Norfolk Boreas Offshore Wind Farm Applicant's Comments on Deadline 15 Submissions

Applicant: Norfolk Boreas Limited
Document Reference: ExA.ASR-D15.D15.5.V1

Date: 08 September 2020
Revision: Version 1
Author: Royal HaskoningDHV

**APPENDIX 2: SLIDES SHOWING ONSHORE PROJECT SUBSTATION
INFRASTRUCTURE (AGENDA ITEM 4 (b) I)**

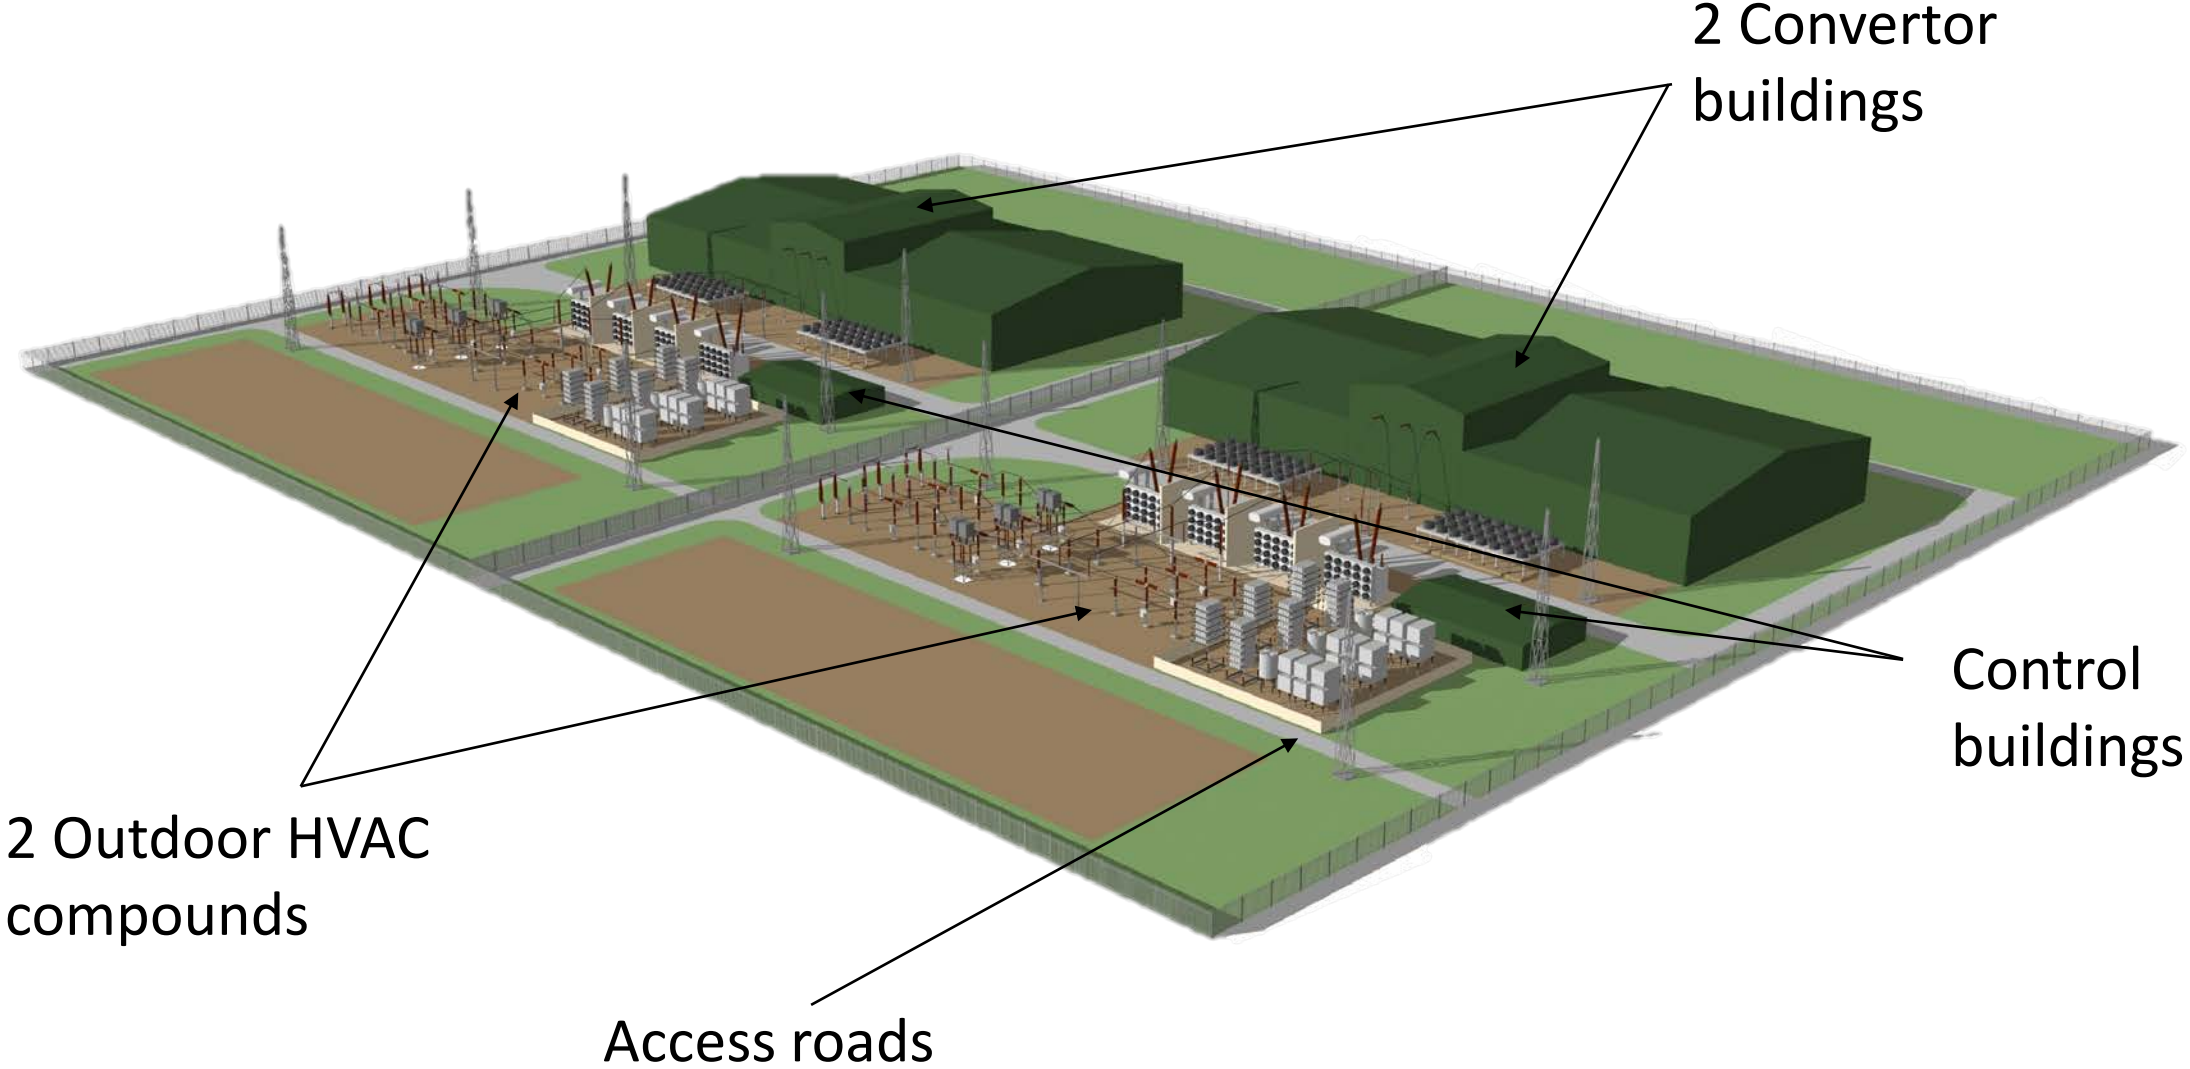
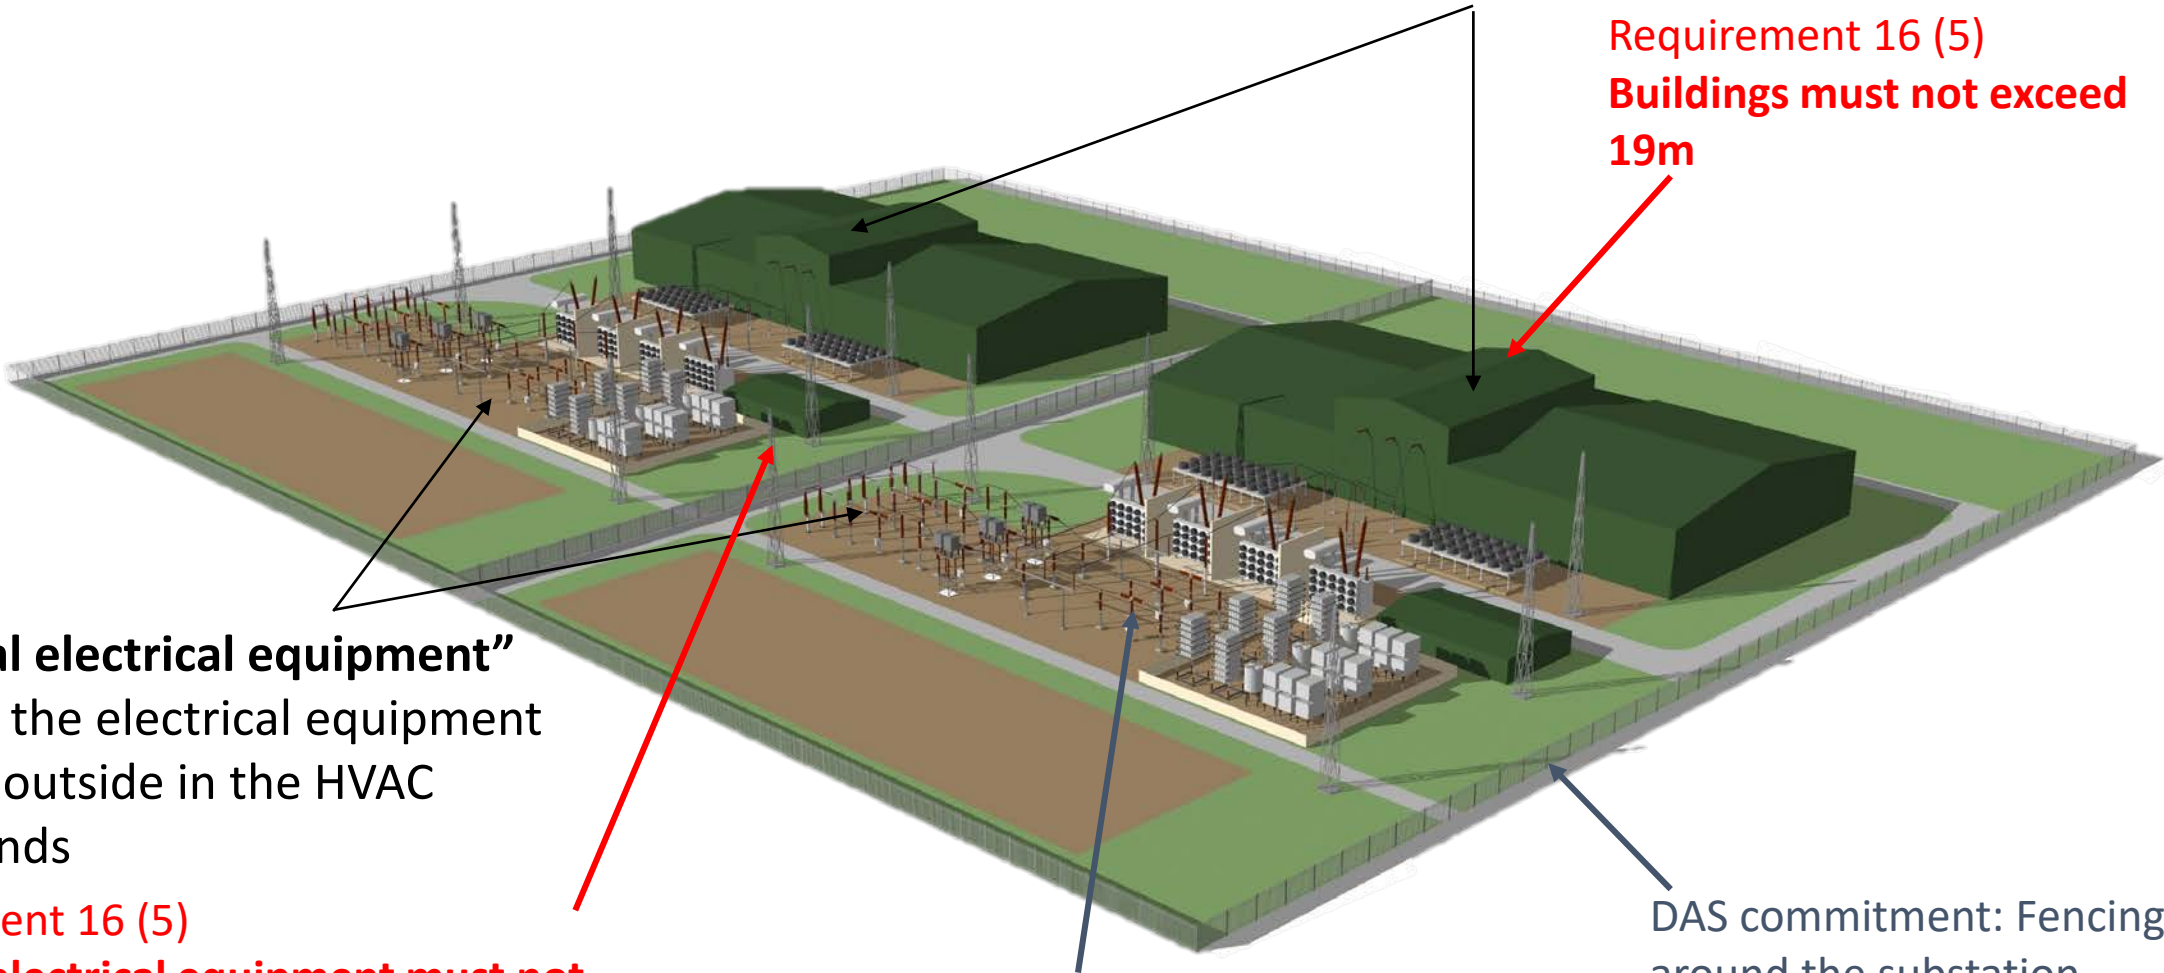
Summary of Submission	Applicant's Comments
Response to Applicant's Comments on Deadline 13 submissions [REP14-39]	
<p>Response to Applicant's comments on Deadline 13 submissions [REP14-039], Section 1.1 response to REP13-042 from NSAG regarding the Rochdale Envelope.</p> <p>REP15-006 believes that the response provided by the Applicant suggests the substation model (converter halls) in the visualisation are shown as a possible underestimation and fail to show the worst case assumptions.</p> <p>REP15-006 considers it is not obvious that the blue dotted box is anything more than the extent of the footprint dimension.</p> <p>REP15-006 considers that the visualisations from viewpoints 2, 3 and 7 give the impression that the converter halls are built out of the site footprint.</p>	<p>Further to the response provided in the Applicant's comments on Deadline 13 submissions [REP14-039], Section 1.1 and Section 1.21, the Applicant would like to clarify that the visualisations of the onshore project substation do not underestimate the levels or extent of visibility.</p> <p>The visualisations reflect the location of the converter halls in the northern part of the site footprint. For technical and environmental reasons, there is a commitment to locate the converter buildings in the north (presented in Figures 9 and 10 of the Design and Access Statement [REP14-019]). Therefore, they will not be located further south and, therefore, the levels or extent of visibility will not increase. The visualisations show the worst case assumptions and further design iterations post consent will either maintain those levels and extent of visibility, or reduce them.</p>

Summary of Submission	Applicant's Comments
	<p>As previously stated, the blue dotted line represents the maximum extents of the onshore project substation, creating a 3D envelope around the developable area. The height of the Rochdale envelope has been set at 25m to ensure that the lightning protection masts are included, despite being relatively fine structures that will not contribute to the perceived mass of the converter halls. The converter buildings have been capped at a maximum height of 19m – 6m lower than the 25m height of the blue dotted line. These dimensions reflect the maximum dimensions which are secured through Requirements 16 (5) of the dDCO. An explanation of this approach (including the use of the blue dotted line) is provided in full in the 'Methodology Statement for the Visualisations' included as part of the Application [APP-509].</p> <p>To clarify the converter halls are contained within the site footprint in all visualisations.</p>
